## Hearing Transcript

<b>Project:</b>	North Falls Offshore Wind Farm
<b>Hearing:</b>	Issue Specific Hearing 2 (ISH2) - Part 6
<b>Date:</b>	10 April 2025

**NF\_10APR\_ISH2\_PT6**

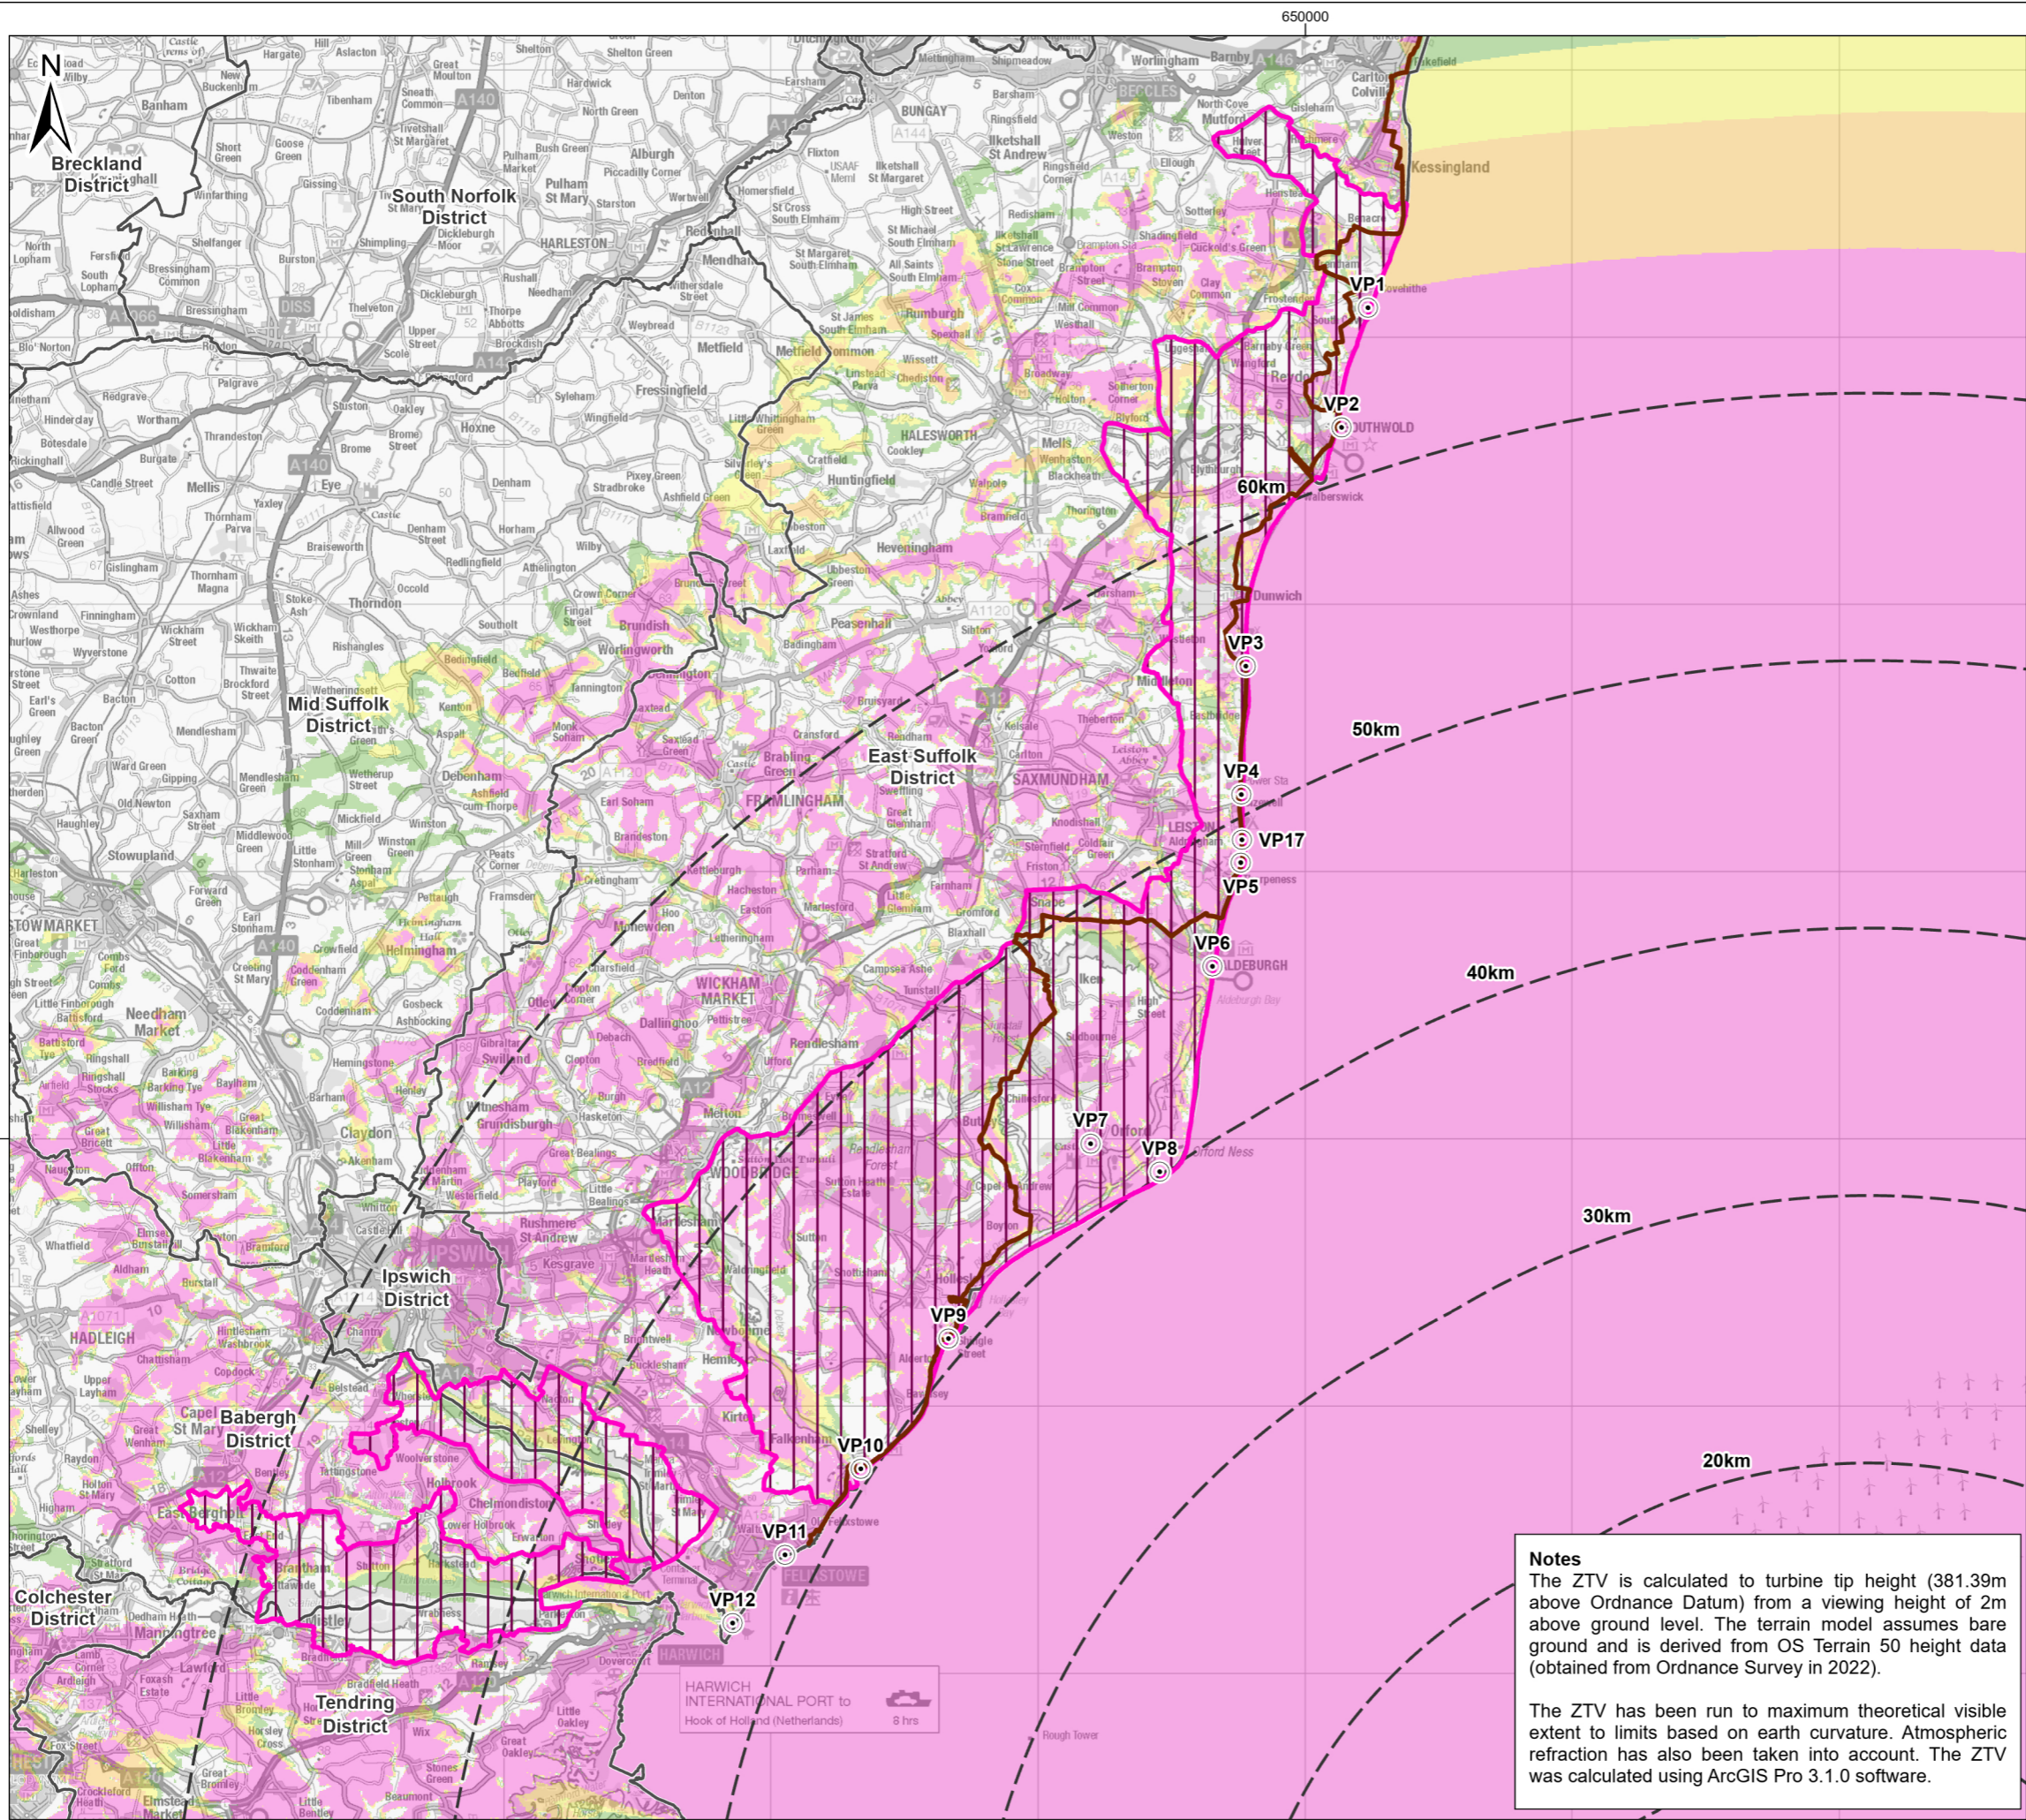
Obviously, the note, the technical note that the applicant has provided Rep 3044,

which seeks to explain its assessment of the special qualities of the National Landscape, stroke AoNB and the Heritage Coast. And we are intending to provide our written comments on that technical note at deadline for, uh, on the 25th of April. Um, as you would expect, but it would very much help us in understanding, uh, what is said in that note.

If the applicant could provide some further clarification today of its approach. And in particular, there is set out in the note a table four which goes through various of the special qualities and indicates the applicant's assessment on the scale of change that the proposals, as now formulated, will have on those special qualities, and in a number of respects, that scale of change is identified as being a medium scale of change.

However, then when you come to what is said, uh, or sorry I should say that is then summarised in paragraph 22 of that note as to the outcome of that exercise. But then when you come to paragraph 23 of that note, uh, it is said by the applicant that the magnitude of impact on what is, I think, agreed to be a high sensitive receptor. That's to say, the national landscape and its special qualities.

The magnitude of impact is put by the applicant in paragraph 23 as low.

170. That's the Slavia methodology. We note that that doesn't seek directly to provide an explanation of the approach taken to the special qualities assessment, and that is confirmed, I think, at paragraph 14 of the technical note. Rep 3044

and so at the moment, we are not clear on the reasoning process that has allowed a series of medium scale of change effects on the special quality to then be said to come to a magnitude of impact, which

is said to be low. And that obviously then feeds into the question of significant or not significant for EIA purposes.
